**Planning reference 3/2021/0356:**

**Location: Wharf Farm, Green Lane, Chipping, PR3 2QE**

**Proposal: Modernization of agricultural buildings, replacing existing housing - complete dairy unit to accommodate 70 cows**

I refer to the email from the Lead Local Flood Authority dated 26<sup>th</sup> August 2021.

Reference
21.1024 - 001

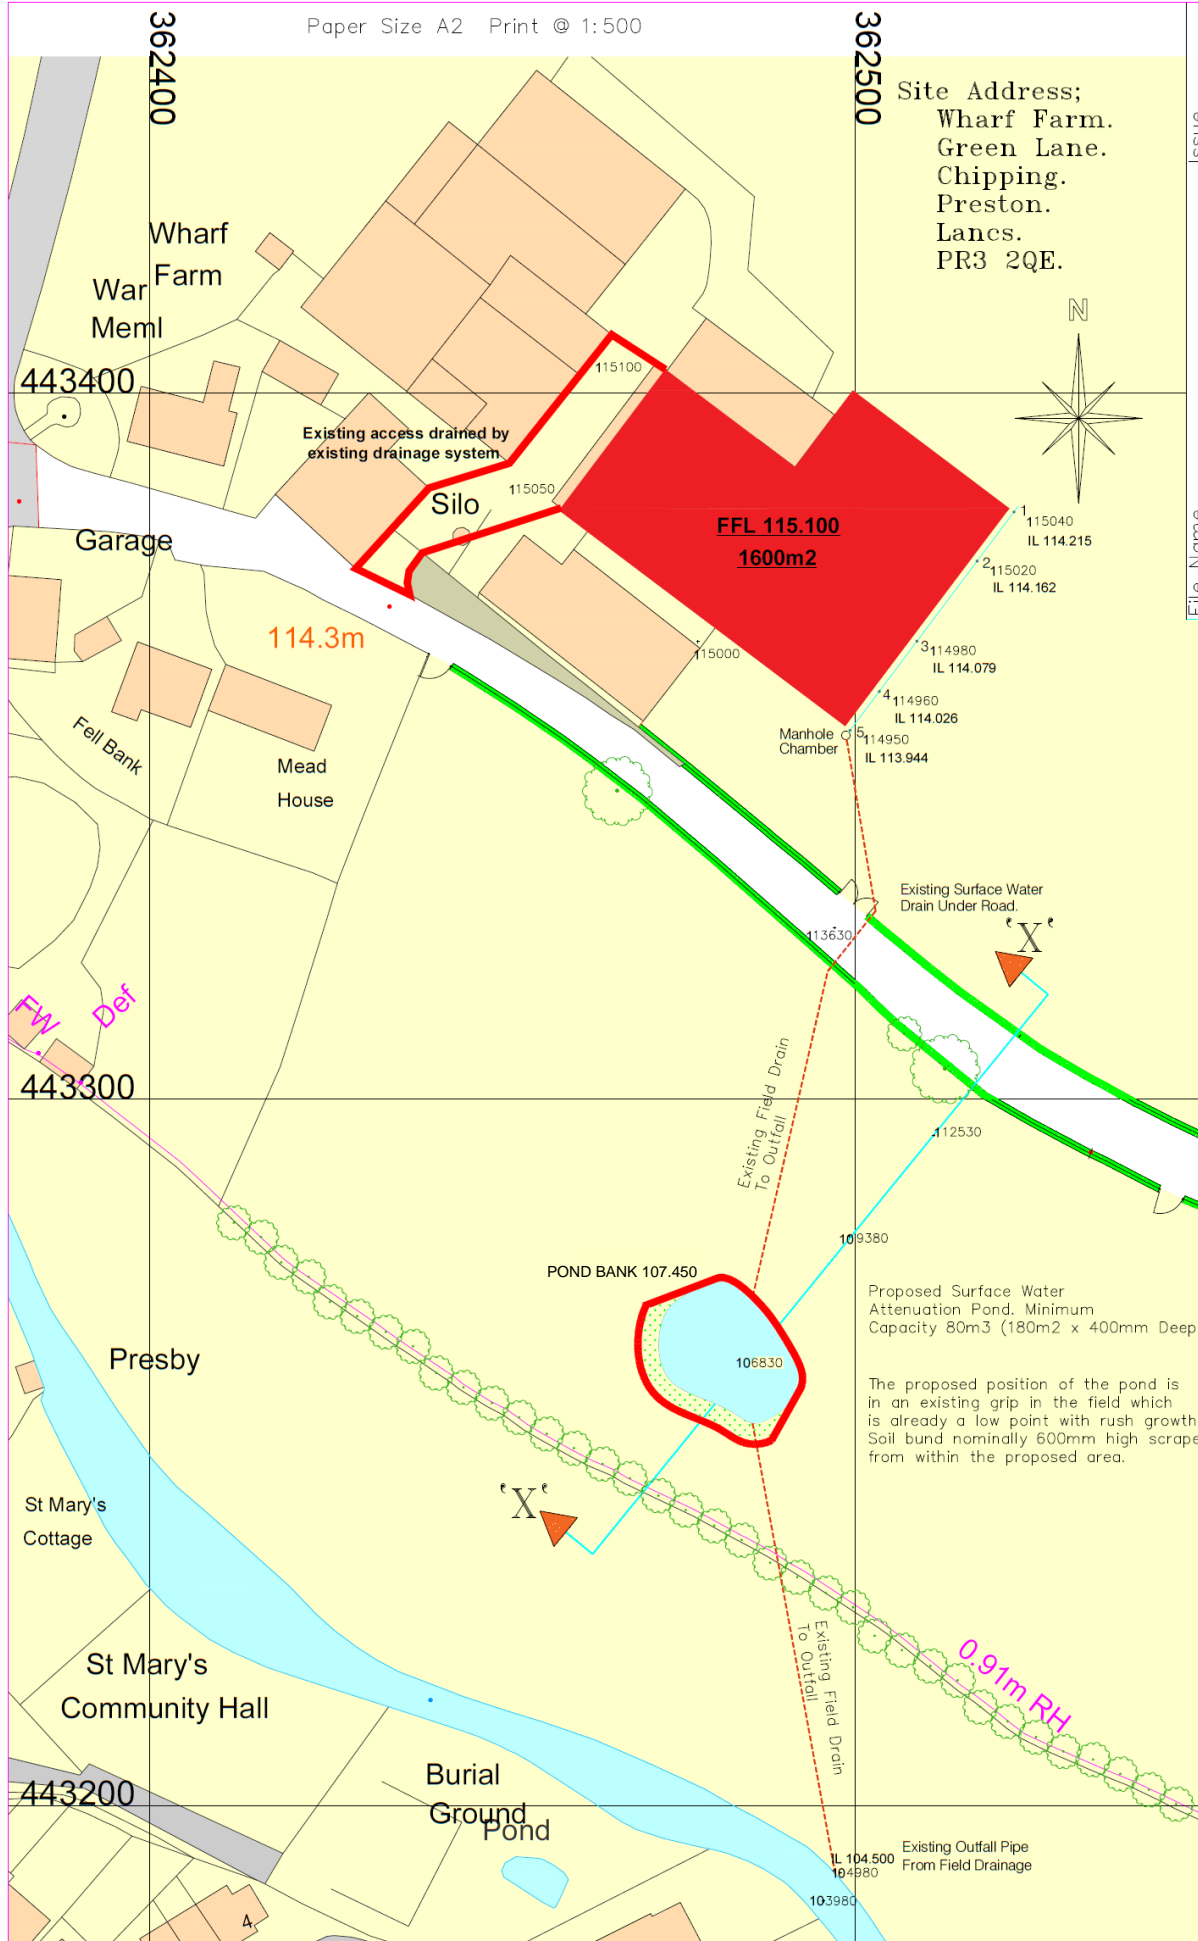
- An updated surface water drainage layout plan showing the drainage proposals for all areas covered by the red edge boundary of the site (including site access etc). Detailed design levels and a drawing reference has also been added to the surface water drainage layout plan for completeness.
- The areas contributing to the proposed surface water drainage network are included on the plan. There are no surface water flows from outside the building curtilage as these are dealt with by the existing drainage system within the site.
- Drawings showing the proposed pond location and a section through the site are included within the report.

- The Finished Floor Level of the building in AOD with adjacent ground levels for all sides of the building are shown on the drawing included within the report.
- The proposed surface water drainage is only collecting roof water from the proposed building as all other surface water runoff within the site is dealt with by the existing drainage system within the site.
- As the surface water runoff is only from the building roof, the runoff is considered to be clean and no pollution will arise.
- Surface water discharge is to the Chipping Brook. A surcharged outfall has not been modelled.
